Tween Bridge Solar Farm

9.4 Statement of Common Ground with the Environment Agency

Document Reference: 9.4

Revision 3

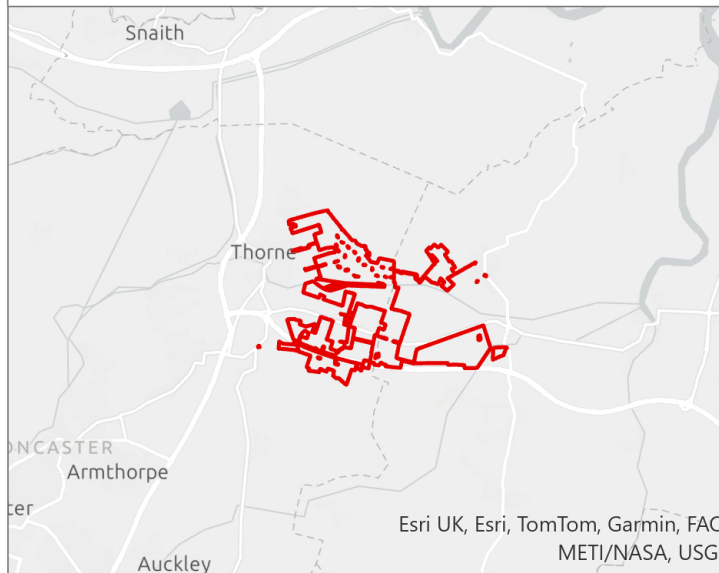
4.	Ecology and Nature Conservation	The EA is concerned with the number of new culverts proposed (45) and the number of locations (125) where either a new culvert or reinforcement/widening of existing culvert/bridge structures may be required, and the impact of these works for habitats.	The Applicant confirms that there are opportunities to deliver enhancements to watercourses across the Order Limits. These measures will include improvements to bankside habitat structure, vegetation management, and measures to improve channel condition.	Agreed
